**WELWYN HATFIELD BOROUGH COUNCIL
DIRECTORATE OF STRATEGY AND DEVELOPMENT**

DELEGATED APPLICATION

Application No: 6/2016/2127/LAWP
Location: 22 Brockwood Lane Welwyn Garden City AL8 7BG
Proposal: Certificate of lawfulness for the erection of a single storey conservatory to the rear of property
Officer: Mr S Dicocco

Recommendation: Refused

Drawing Title:
PROPOSED ELEVATIONS AND PLAN

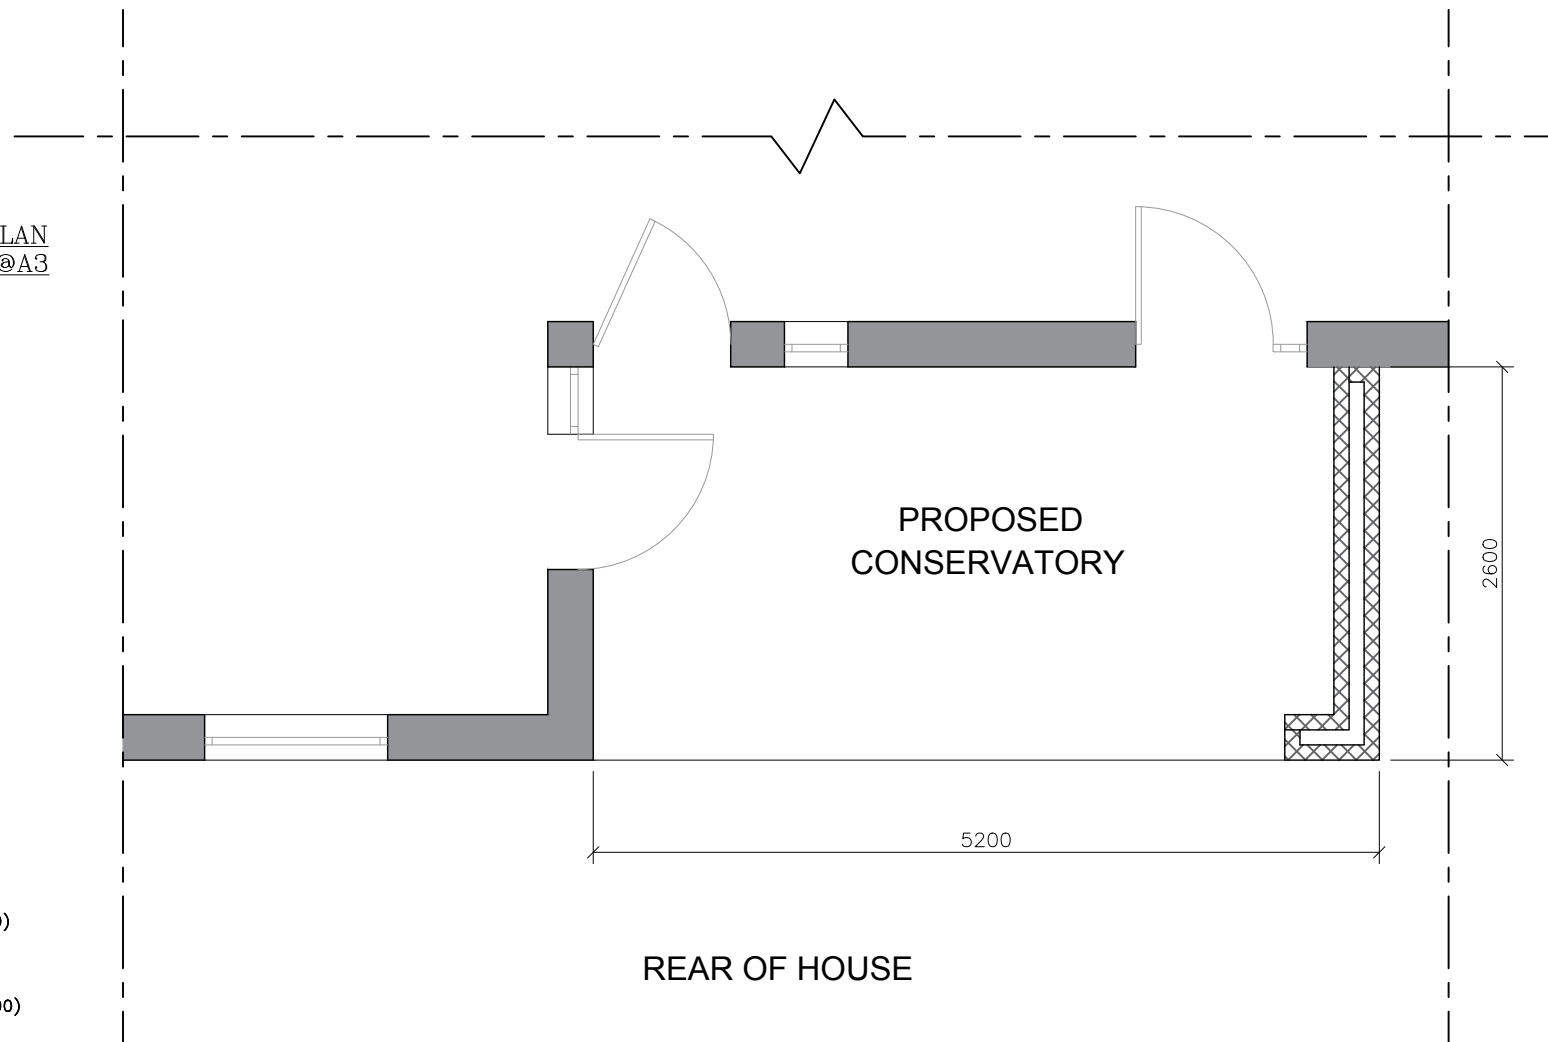
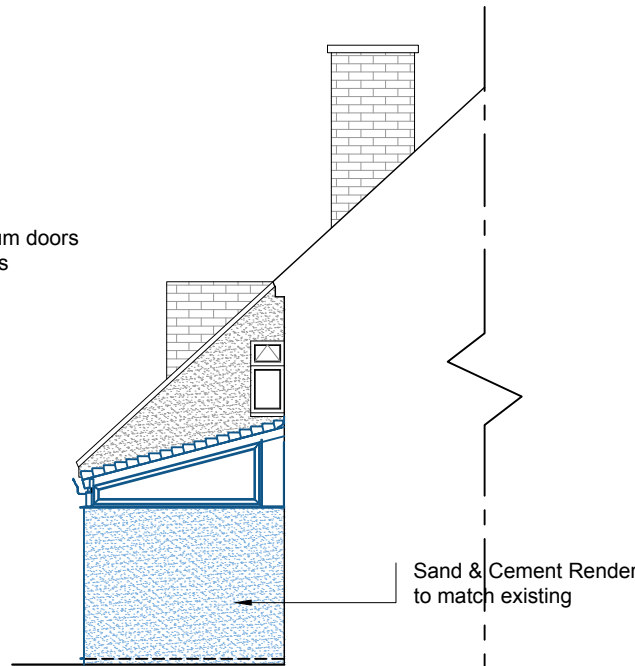
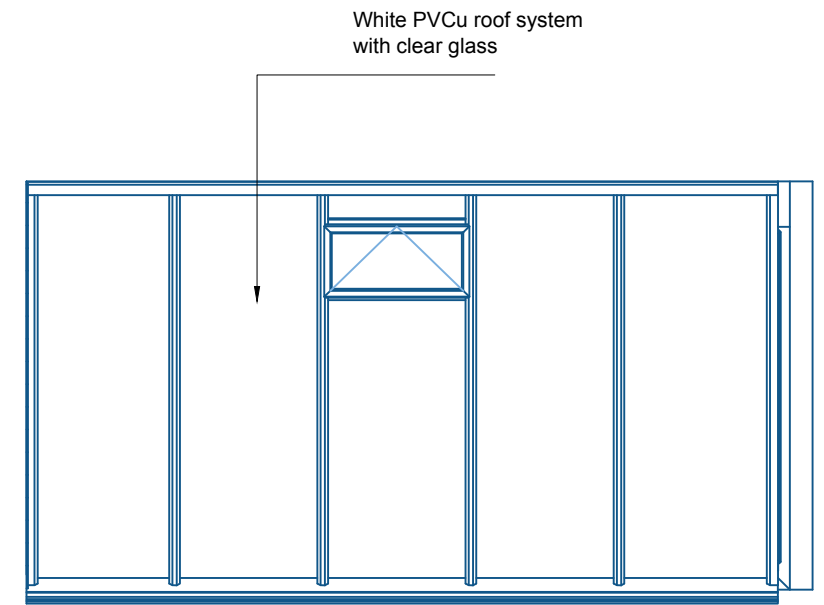
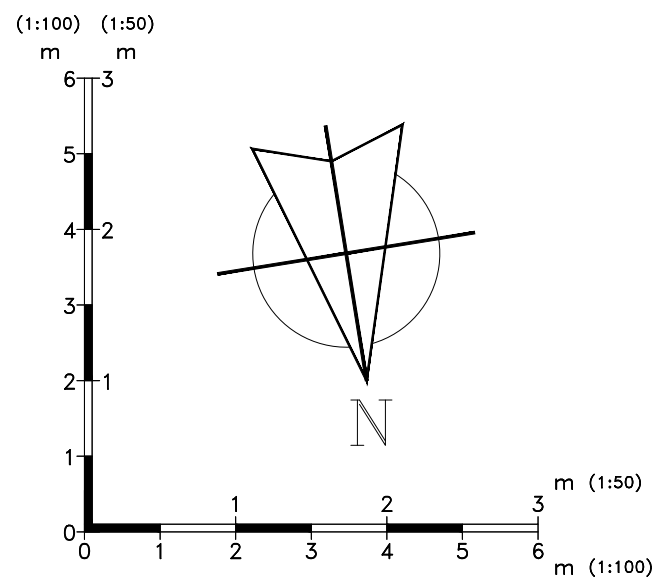
(j) would the enlarged part of the dwellinghouse extend beyond a wall forming a side elevation of the original dwellinghouse, and:- (i) exceed 4 metres in height, (ii) have more than one storey, or (iii) have a width greater than half the width of the original dwellinghouse	Y N 3.2m N Y 5.2m	N

(b) the enlarged part of the dwellinghouse would extend beyond a wall forming a side elevation of the original dwellinghouse;	Y	N
(c) the enlarged part of the dwellinghouse would have more than one storey and extend beyond the rear wall of the original dwellinghouse	N/A	N
A.3 Development is permitted by Class A subject to the following conditions:- (a) would the materials used in any exterior work (other than materials used in the	Y	Y
